18 January 2019
L.19.01.17 Revised Proposals

**Application Ref. 3/2018/0914 - Phase 2 Lawsonsteads,
Whalley**

This letter relates to the above application and specifically responds to the comments received from yourself dated 19th December 2018 which followed our meeting at the Council offices on the 6th December 2018. It is noted that we are still awaiting your elevational sketches and comments on the revised buffer sketch relating to plots 143-150.

**AA7403 2031**  
**REV A**  
**INFORMATION**

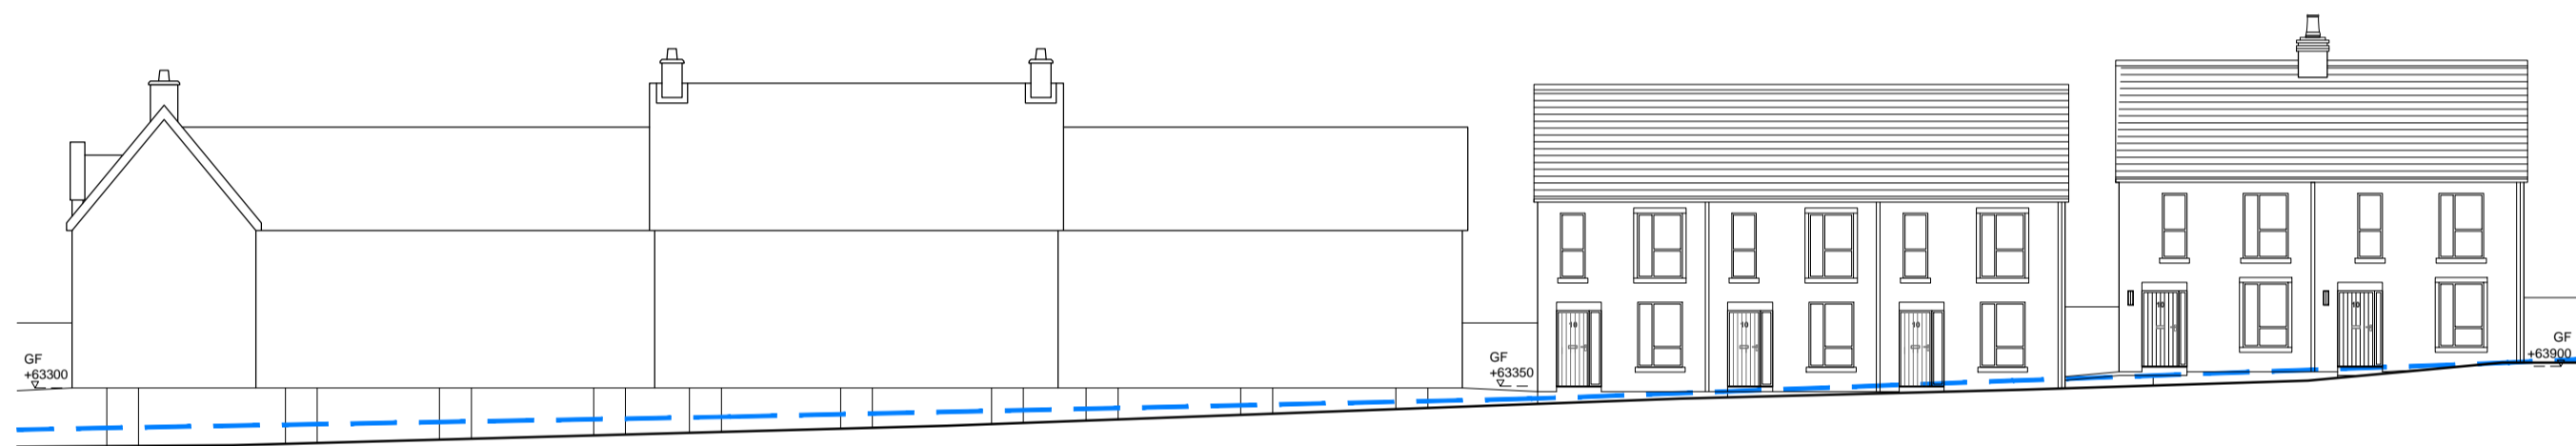
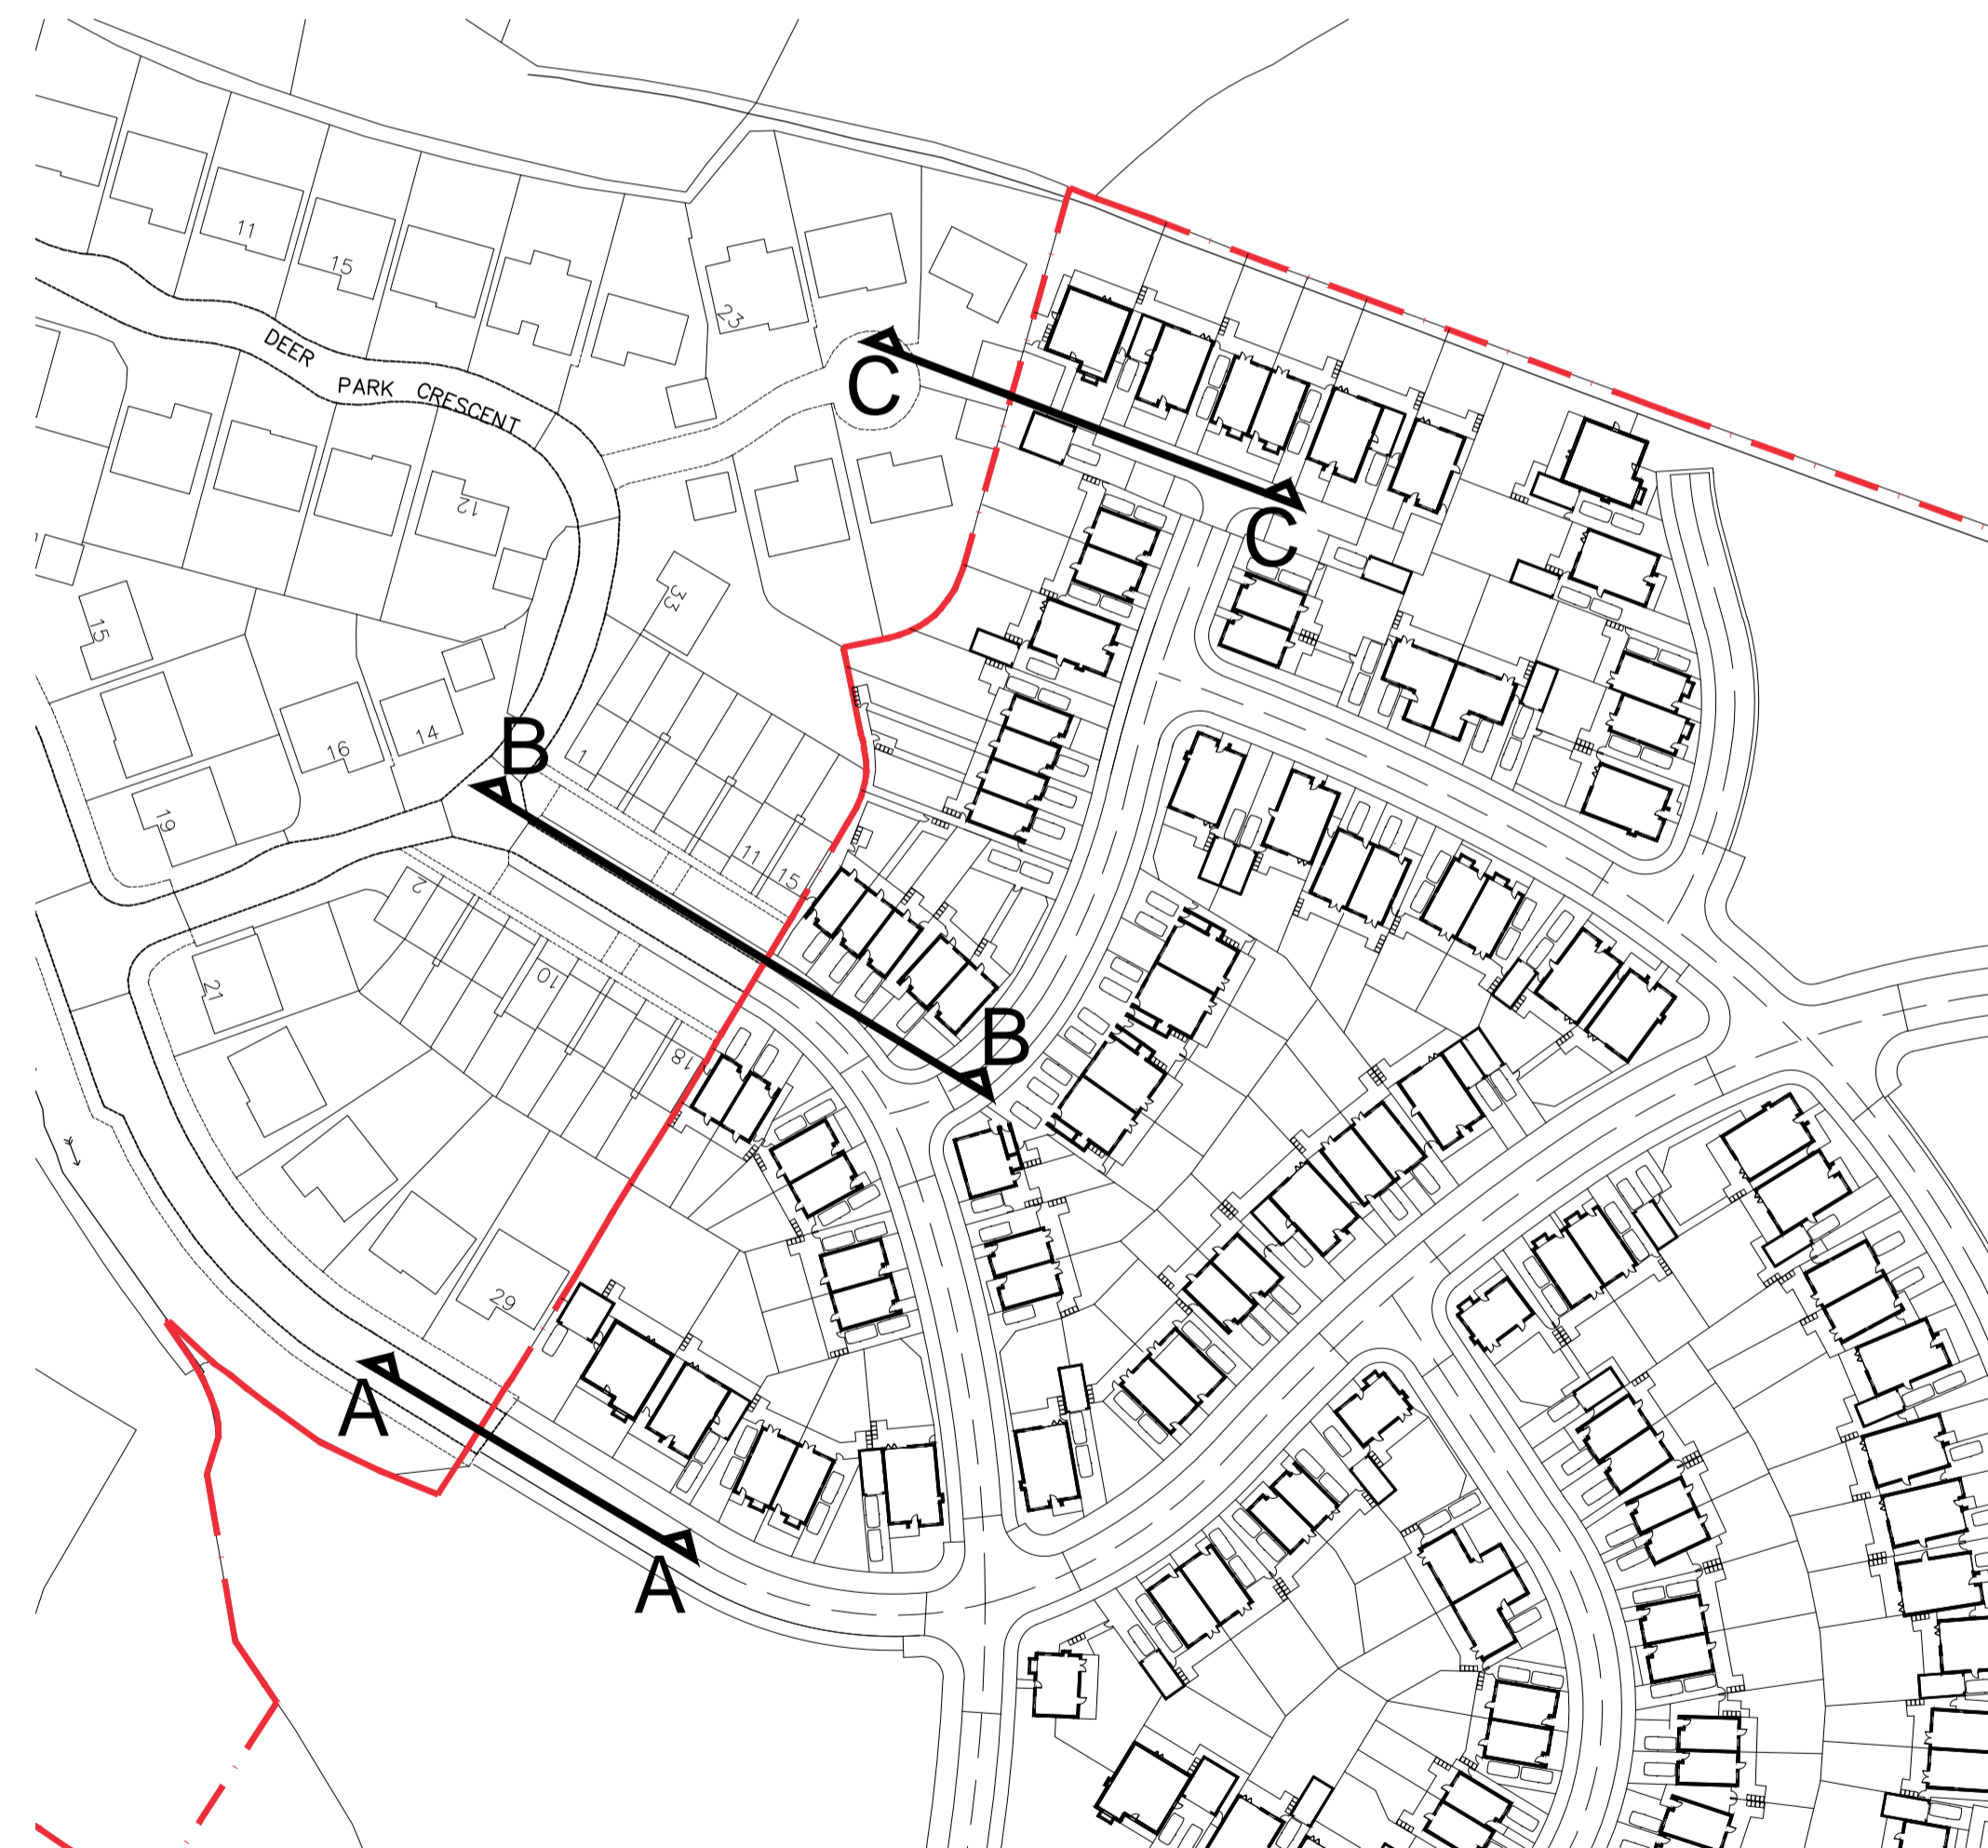
4.1 I note that you have increased the offset/interface distances between the proposed dwellings in the southern parcel and the existing neighbouring properties on Woodlands Park and Sydney Avenue. I also note the submission of cross-sections that take account of changes in topography. I would request that such information forms part of any formal resubmission package.

Noted, drawings 'AA7403 2030 Existing and Proposed Sections 01' and 'AA7403 2031 A Existing and Proposed Sections 02' form part of the submission pack.

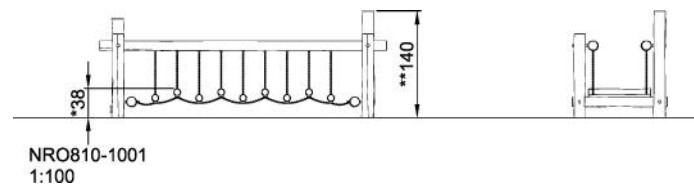
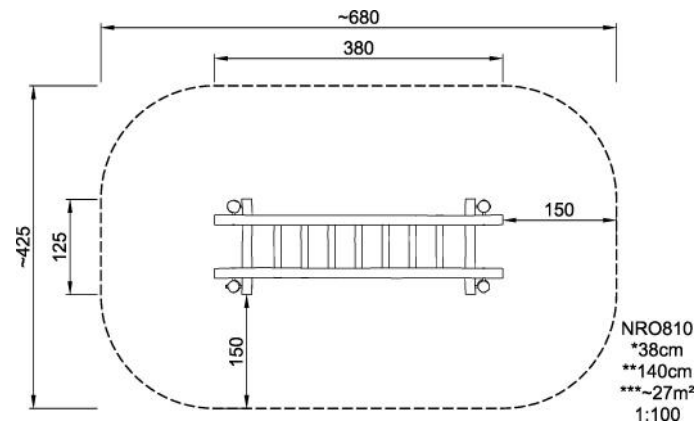
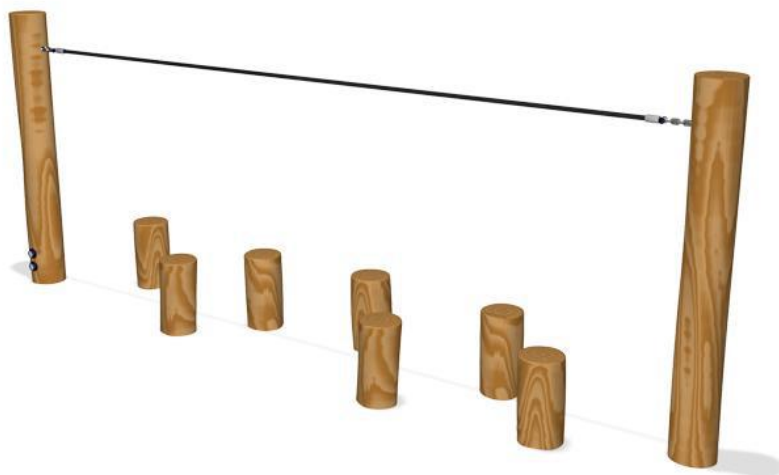
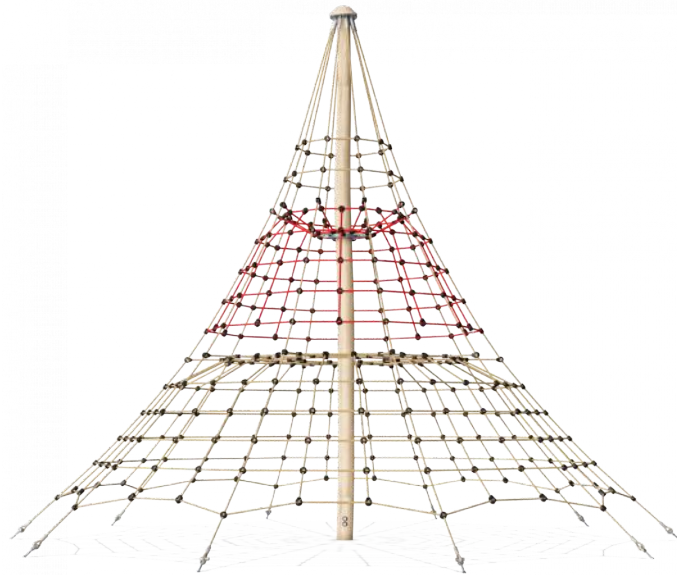
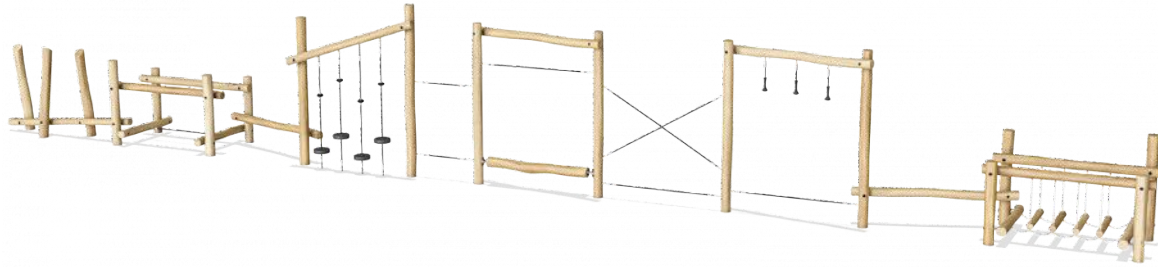
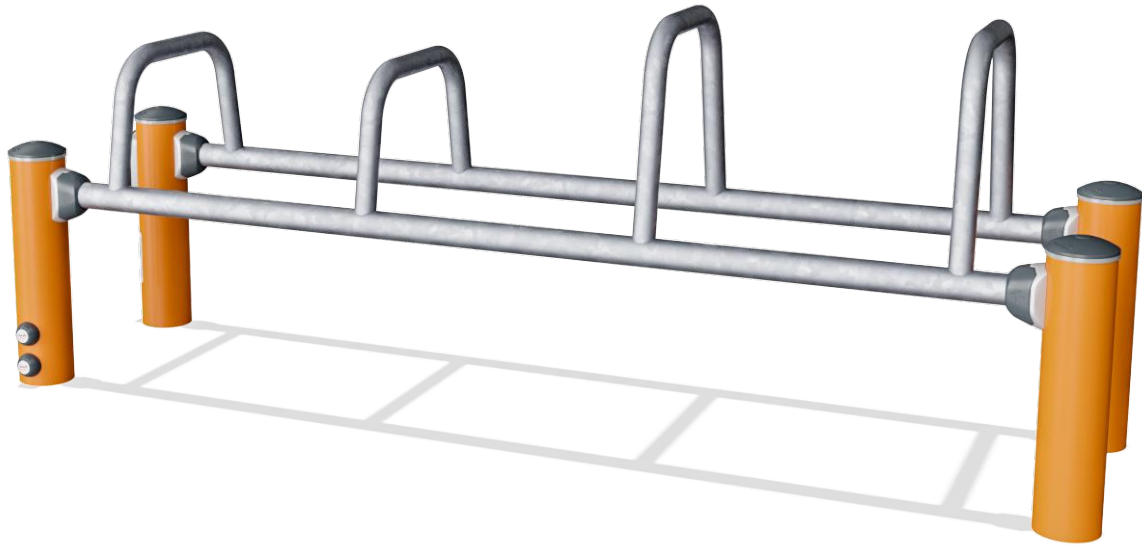
5.4 No details of the proposed trim-trail equipment have been provided at this stage despite requesting this to be submitted as part of the application. For the purposes of public consultation I consider such details should form part of the submission.

As above.
